<b>Location of Construction:</b> 4 King St	<b>Owner Name:</b> Plummer Sheryl C	<b>Owner Address:</b> 10 Derby Rd	<b>Phone:</b> 775-7670
<b>Business Name:</b>	<b>Contractor Name:</b> F. S. Plummer Co., INC	<b>Contractor Address:</b> 80 Pinetree Industrial Pkwy Portland	<b>Phone</b> 2078286711
<b>Lessee/Buyer's Name</b>	<b>Phone:</b>	<b>Permit Type:</b> Garages - Detached	<b>Zone:</b>

<b>Dept:</b> Zoning	<b>Status:</b> Pending	<b>Reviewer:</b> Jeanine Bourke	<b>Approval Date:</b>
<b>Note:</b> 11/10/03 Mark P. Did not show up for same day appt. Issues with lot coverage and need rear setback dimension. 11/26/03 Submitted surveyors plan showing the lot to be 4,144 square feet. Mark P. Will submit an original with the placement of the new garage and setbacks.			<b>Ok to Issue:</b> <input type="checkbox"/>

OF PROPERTY LOCATED AT  
4 KING STREET, PORTLAND, MAINE  
SCALE: 1 INCH = 20 FEET NOVEMBER 24, 2003  
SURVEYED BY:  
AUSTIN LAND SURVEYING, L.L.C.  
82 ELDERBERRY LANE  
NEW GLOUCESTER, MAINE 04260

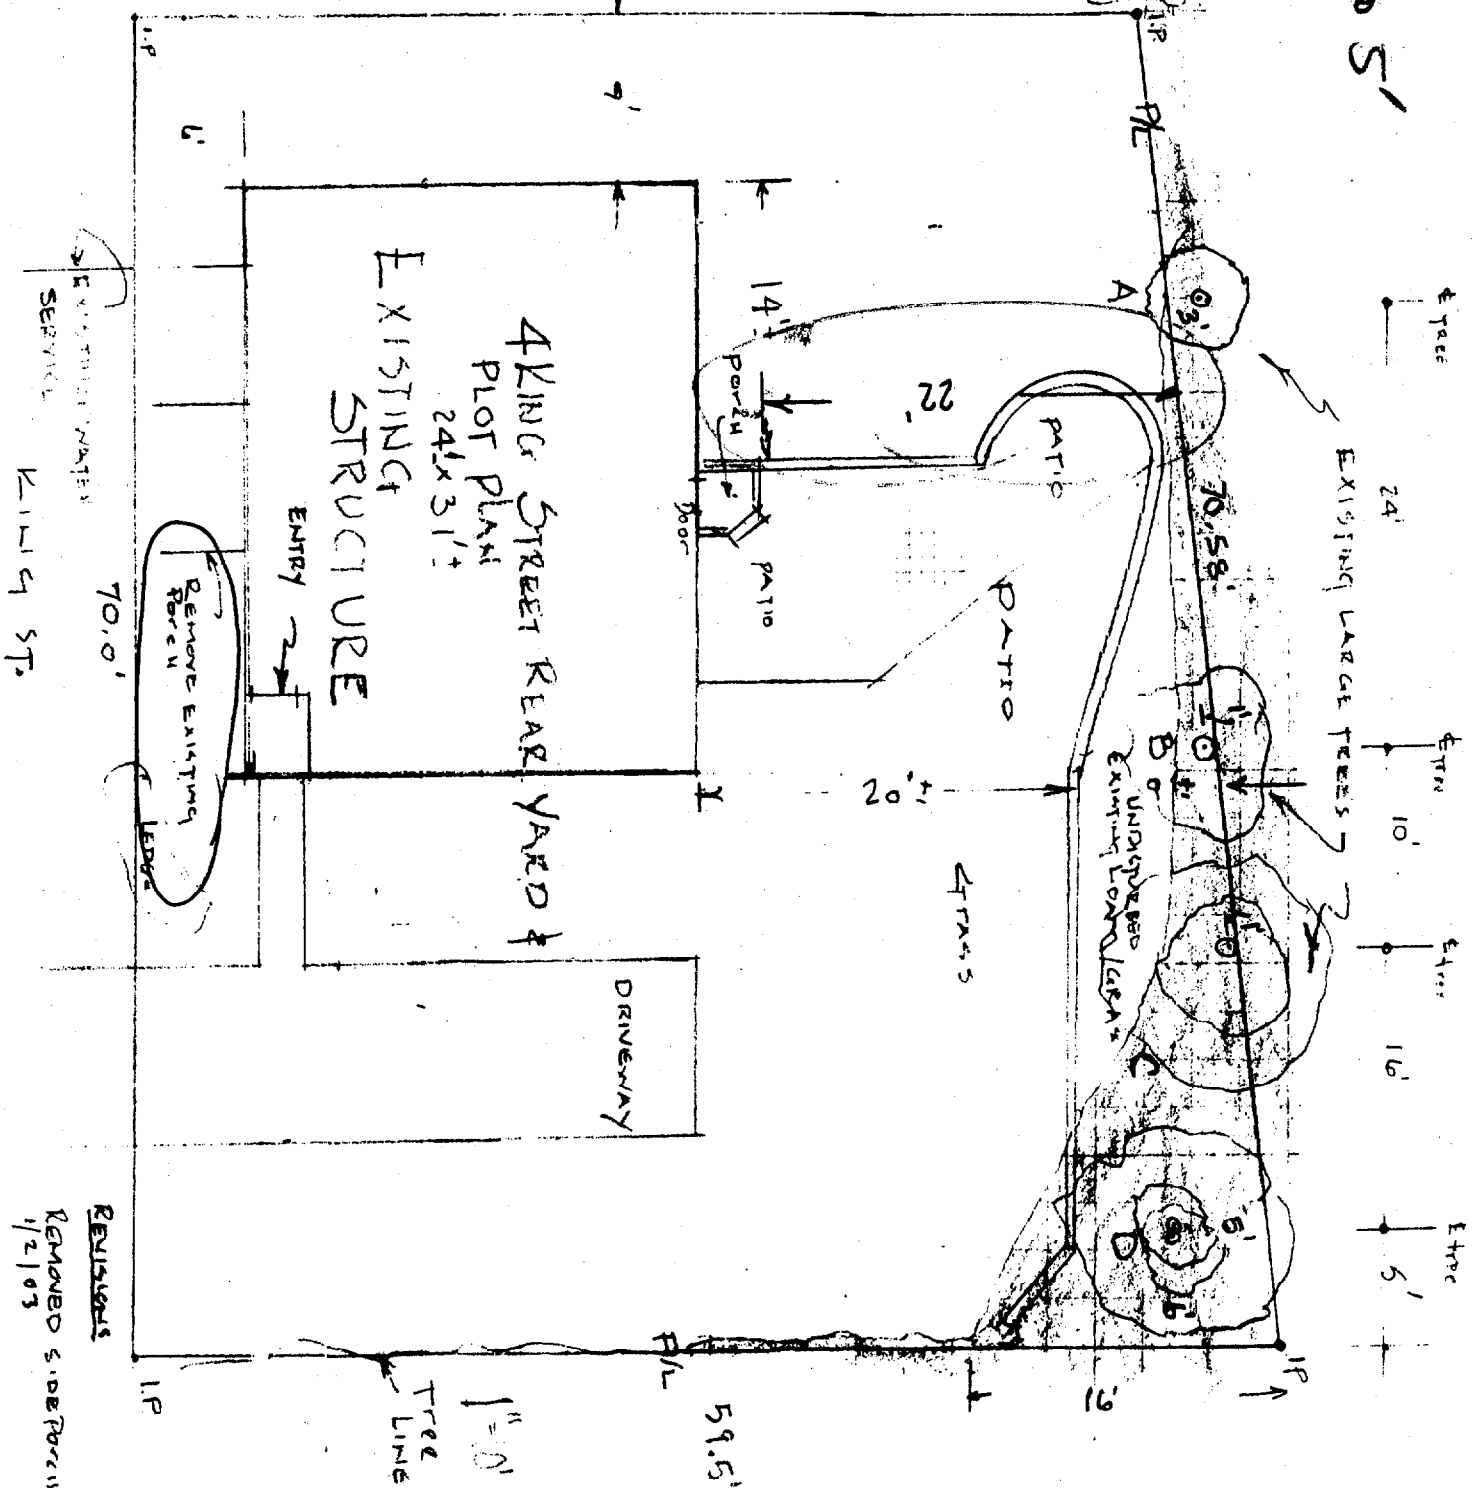
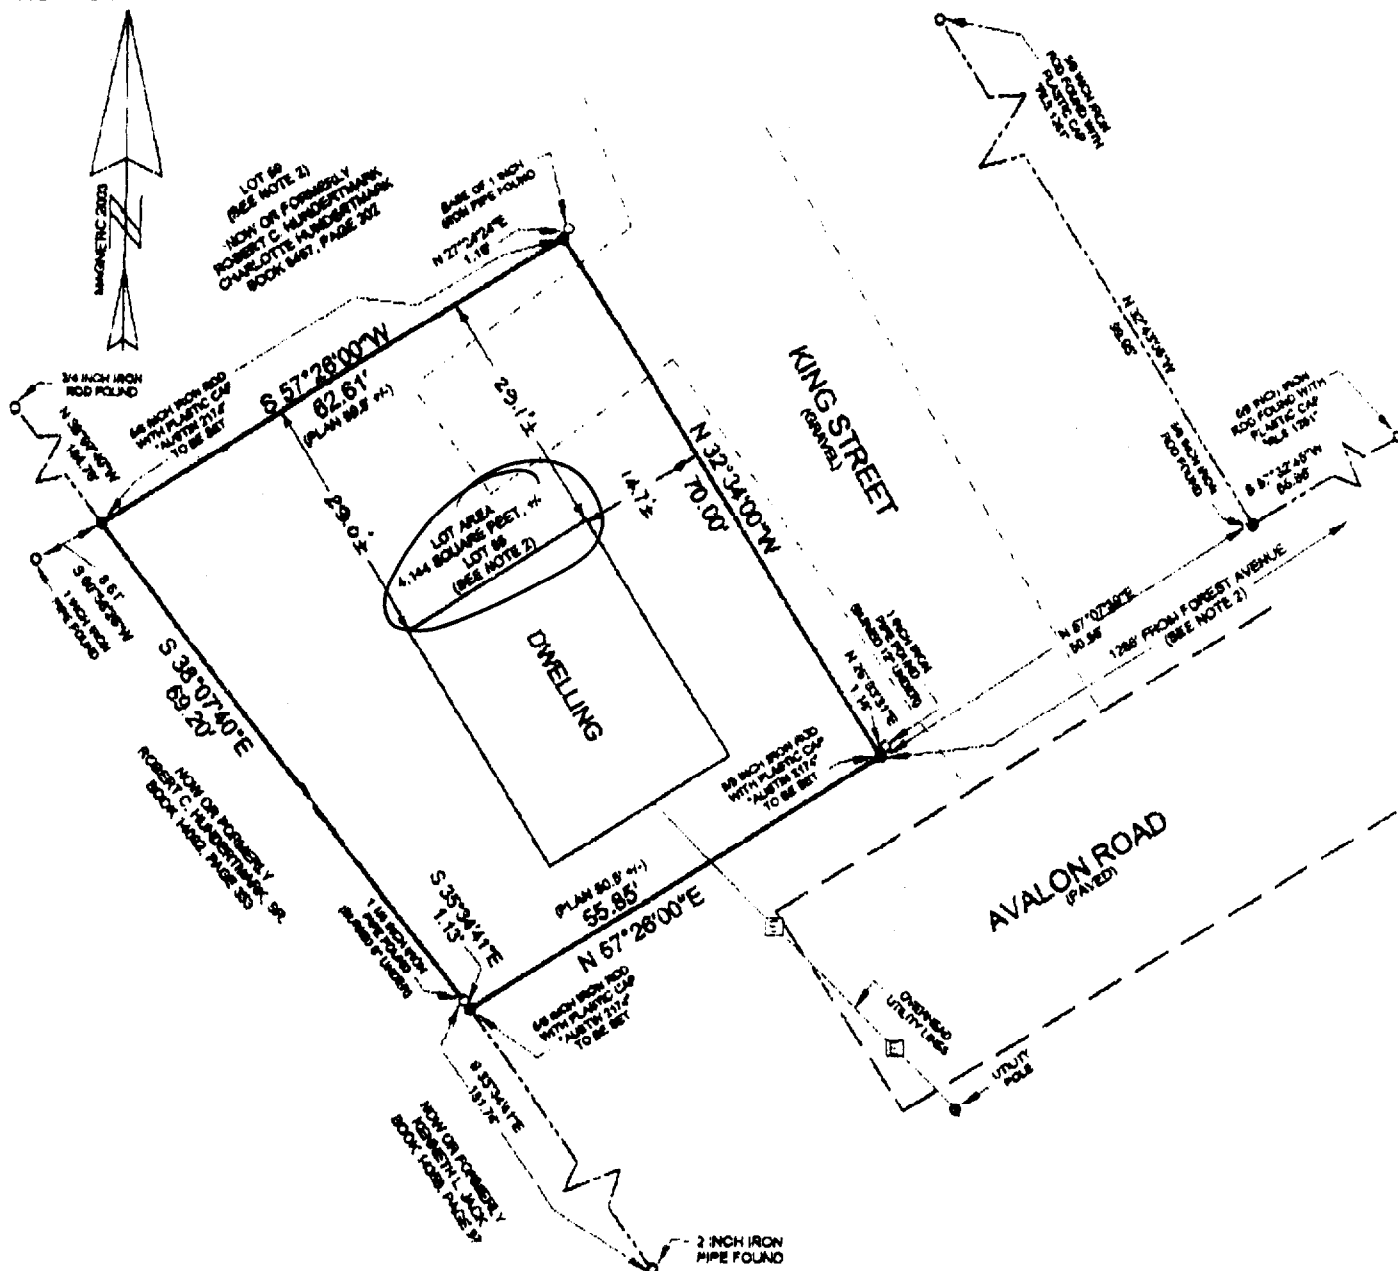
1) This permit is issued under Section 14-433 which allows a reduction of the rear setback. The accessory garage must meet the required 25' front setback and the lot depth is such that the 25' required in the rear cannot be met.
